**TO:** All Staff  
**FROM:** Public Works Plan Review Team  
**DATE:** May 23, 2024  
**SUBJECT:** SP-24-00007 Davenport

## KVFR Prevention Short Plat Comments

Project: Davenport Short Plat of TPN 556136

Permit#: SP-24-00007

DAVENPORT SHORT PLAT

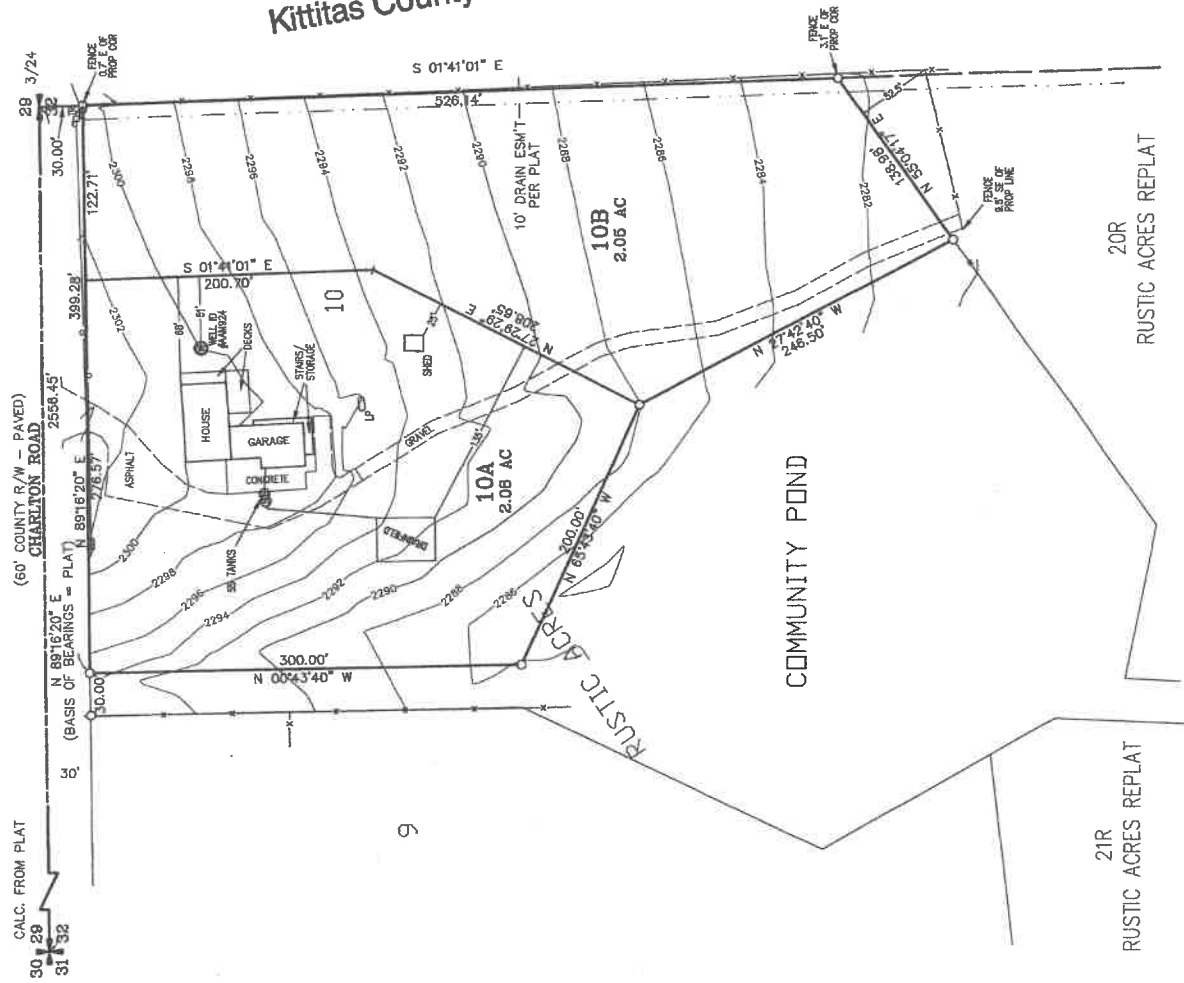
<b>ACCESS</b>	<ol style="list-style-type: none"><li>1. An approved access permit shall be required from the Kittitas County Department of Public Works prior to creating any new driveway access or altering an existing access.</li><li>2. Maintenance of driveway approaches shall be the responsibility of the owner whose property they serve. The County will not maintain accesses.</li><li>3. Any further subdivision or lots to be served by proposed access may result in further access requirements. See Kittitas County Road Standards.</li><li>4. In addition to the above-mentioned conditions, all applicable Kittitas County Road Standards apply to this proposal. Access is not guaranteed to any existing or created parcel on this application.</li></ol> <p>OFF NOTE:</p> <ol style="list-style-type: none"><li>5. Please ensure that the parcel with the existing home addressed as 700 Charlton Road retains the address upon final recording of short plat. (JS)</li></ol>

<b>ENGINEERING</b>	Except as exempted in KCC 14.05.060, no grading or filling upon a site involving more than one hundred (100) cubic yards shall be performed without a grading permit from the County Engineer or Public Works designee (KCC 14.05.050). An application for grading in excess of five hundred (500) cubic yards shall be accompanied by an engineered grading plan (KCC 14.05.080).
<b>SURVEY</b>	There are no survey comments regarding this preliminary Short Plat. (JT) Title and closures will be reviewed at final.
<b>TRANSPORTATION CONCURRENCY</b>	No transportation concurrency management application is required for this project. (JS)

- Fire apparatus access roads exceeding 150' shall be provided with a temporary or permanent turnaround meeting the requirement 2021 IFC Appendix D.
- Fire apparatus access roads shall not exceed 10% in grade. This is especially critical in our valley's climate.
- The IFC Appendix D requires the road be a minimum of 20' wide and capable of supporting an imposed load of at least 75,000 lbs.
- Road turning radius required under IFC Appendix D are a minimum of 23' inside and 45' outside.
- Any future construction on the parcels shall be required to meet all water fire flow requirements as adopted by Kittitas County under WUI code and International Fire code.
